Application Correspondence (both Y/31/21/PL & Y/32/21/A)

Subject: Barratt Temp Sales Office Applications (Y/31/21/PL & Y/32/21/A), Land at Drove lane, Yapton

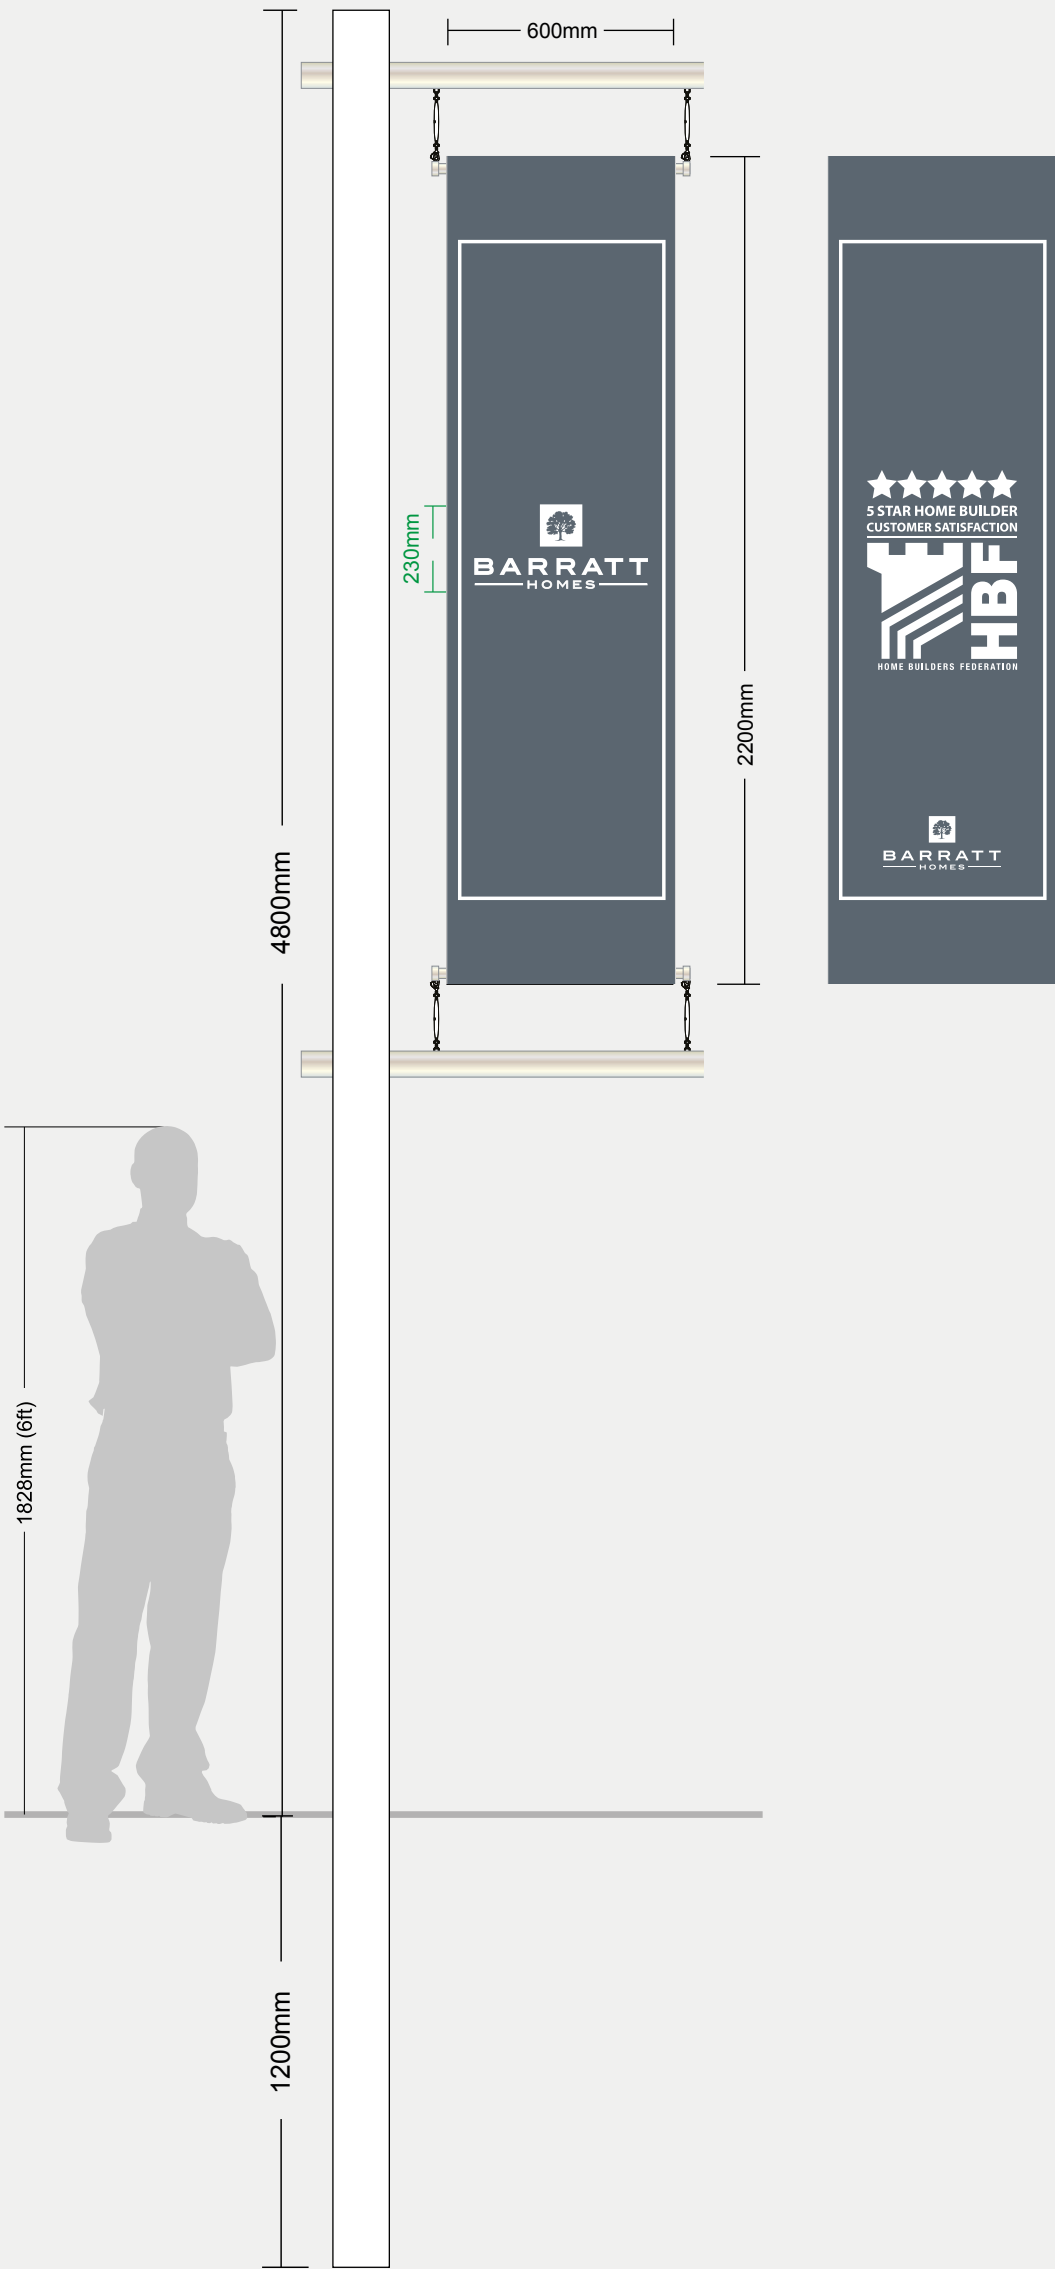
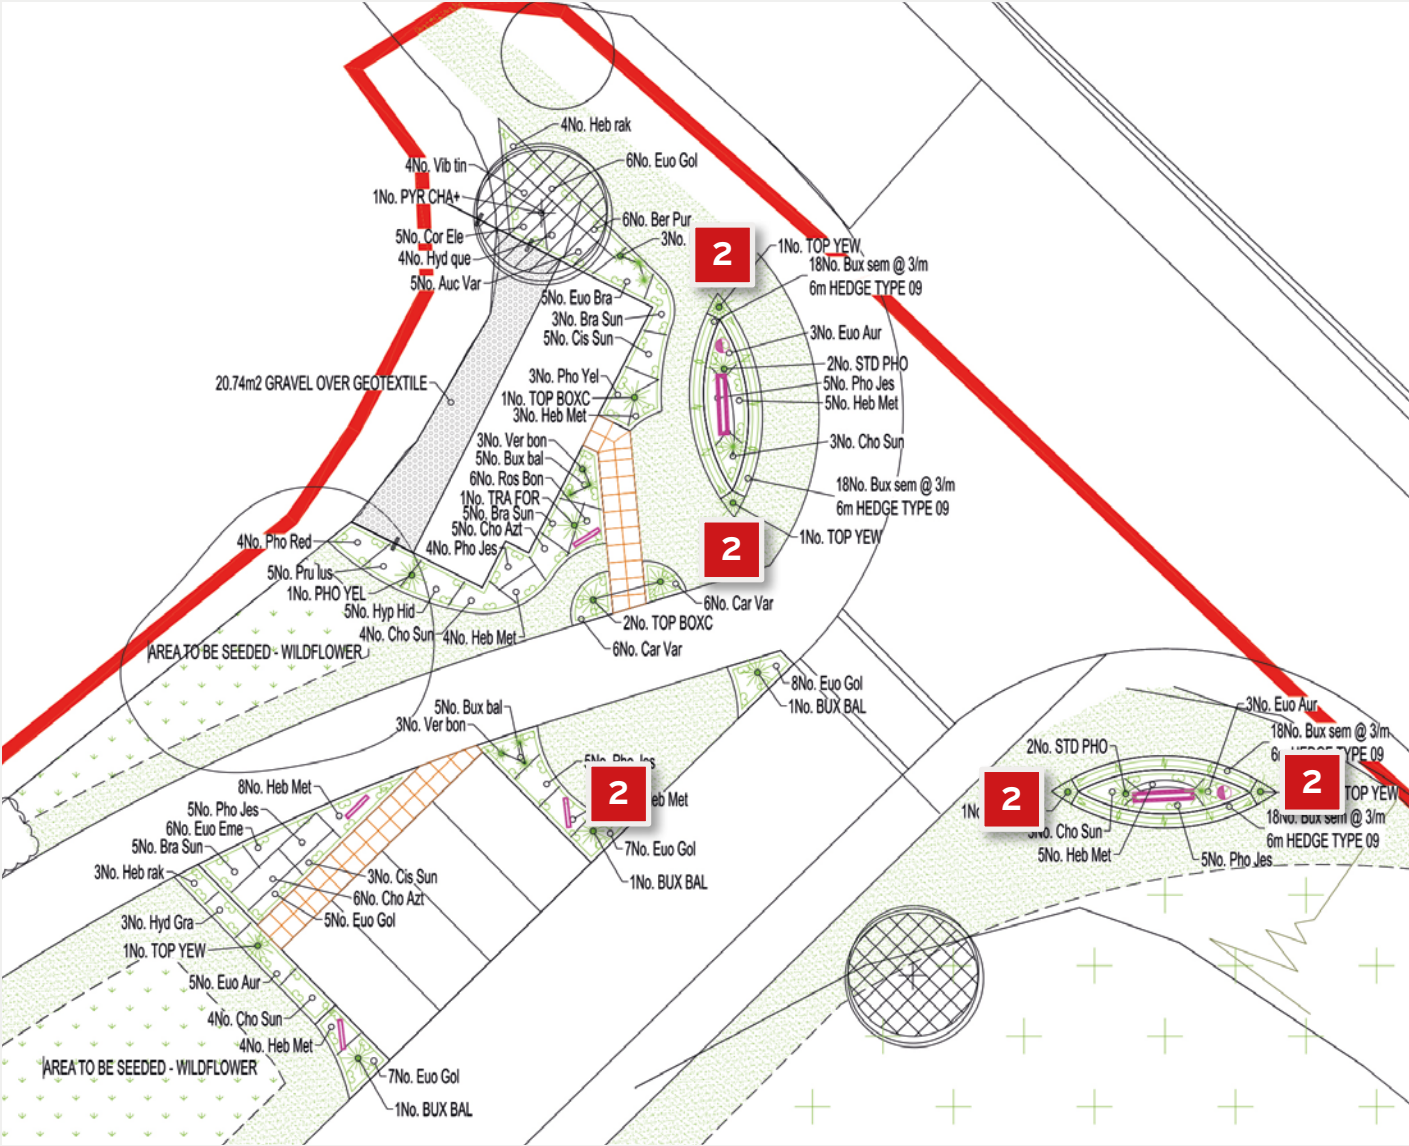
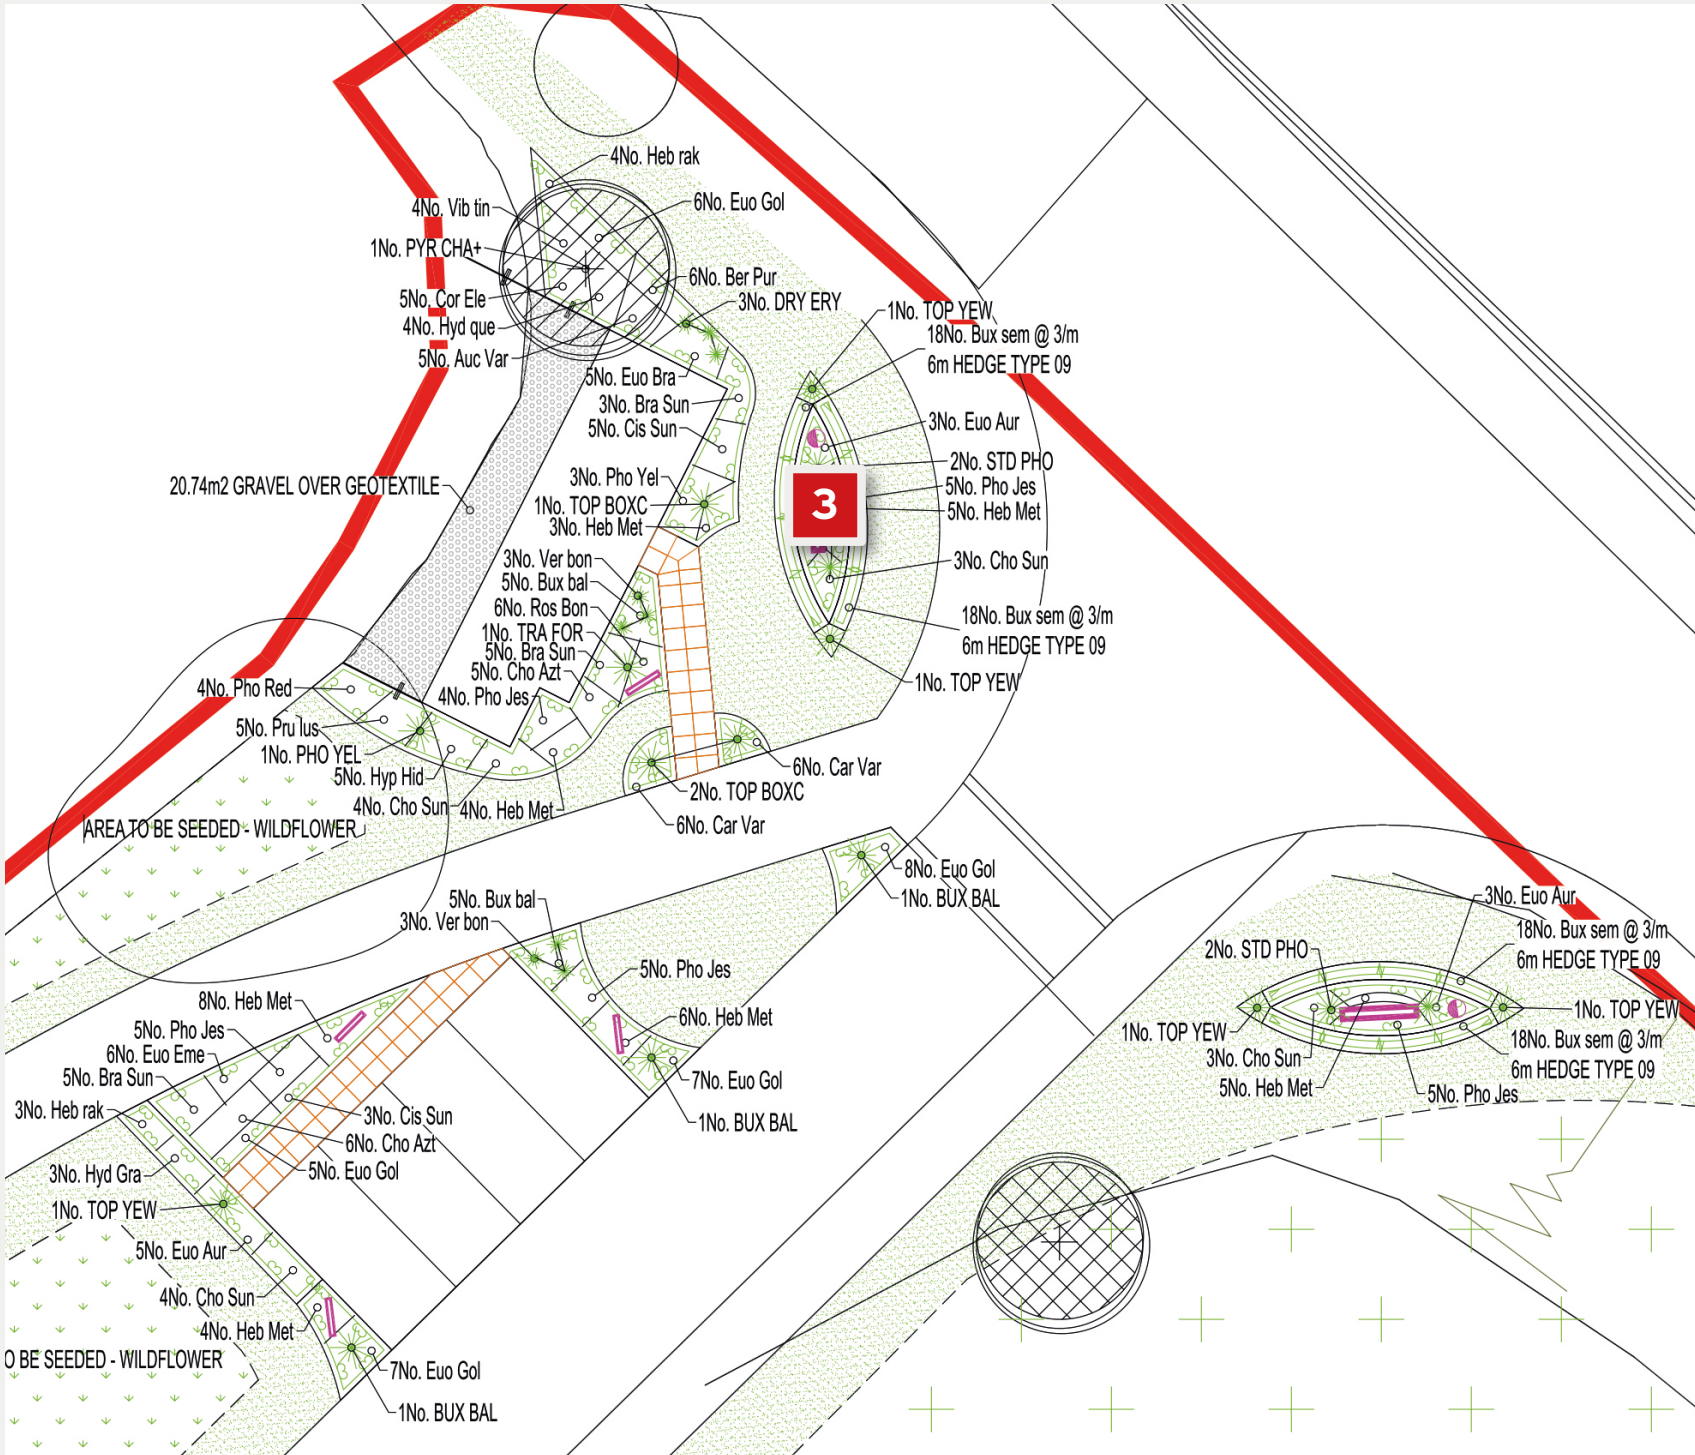
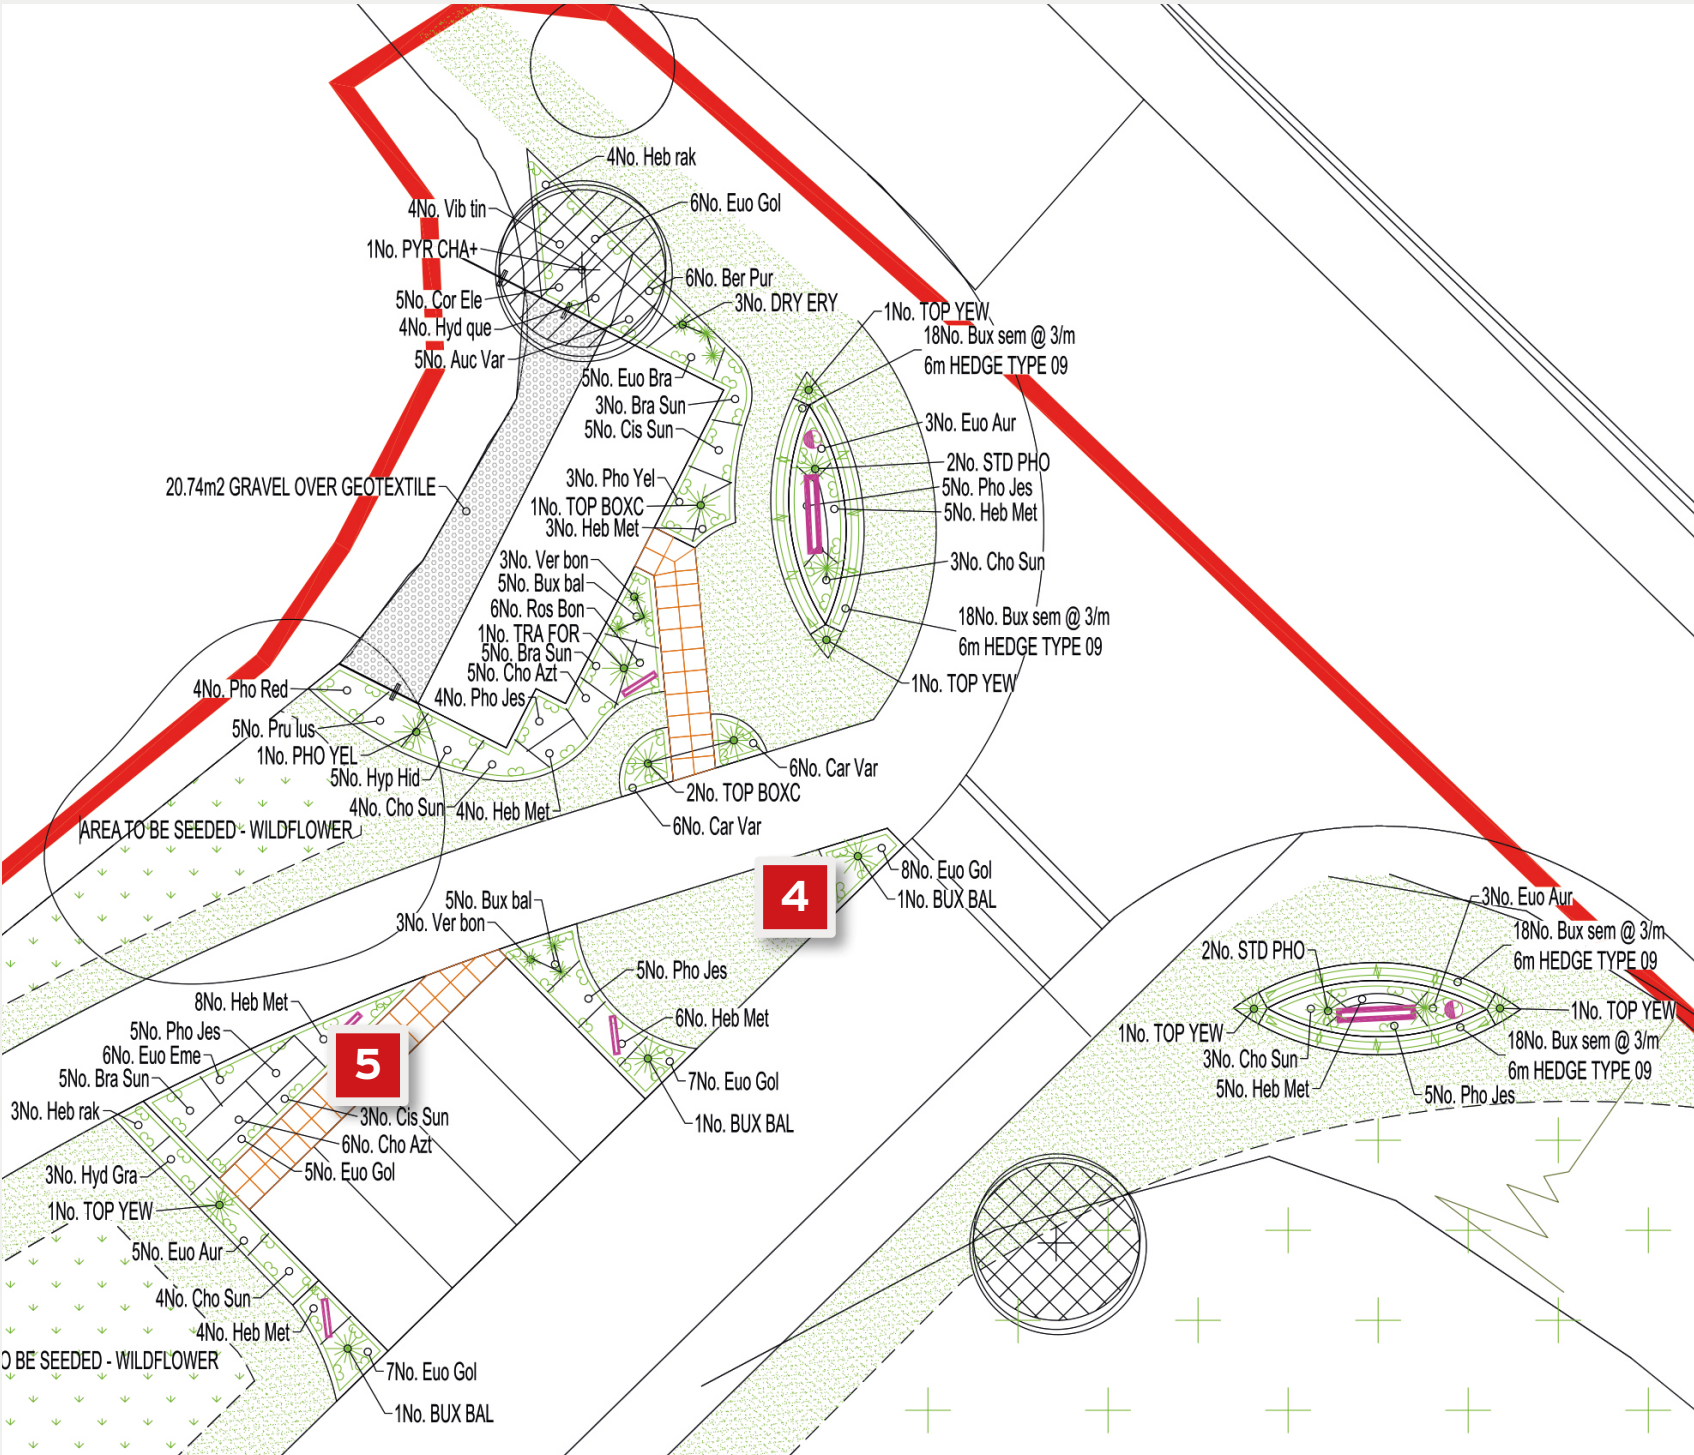
I write to alert you that it is our intention to refuse these two applications on the grounds of visual harm to the nearby heritage assets and to the character of the area/streetscene. You may also have noted on the application files the comments of our Conservation Officer and the Parish Council. I also consider that the amount of freestanding adverts/signs in the temporary area is excessive in such a sensitive location.

I acknowledge that the proposal is temporary (albeit it is unclear as to how long it would be in place for) but it is still likely to be in place for some period of time whilst the permanent sales area is built out. I note that the adverts are proposed for a 2 year period. In addition, this application does appear a little premature given that the previous refusal and that a resubmission has only recently been resubmitted – your application states the adverts are required from June this year?
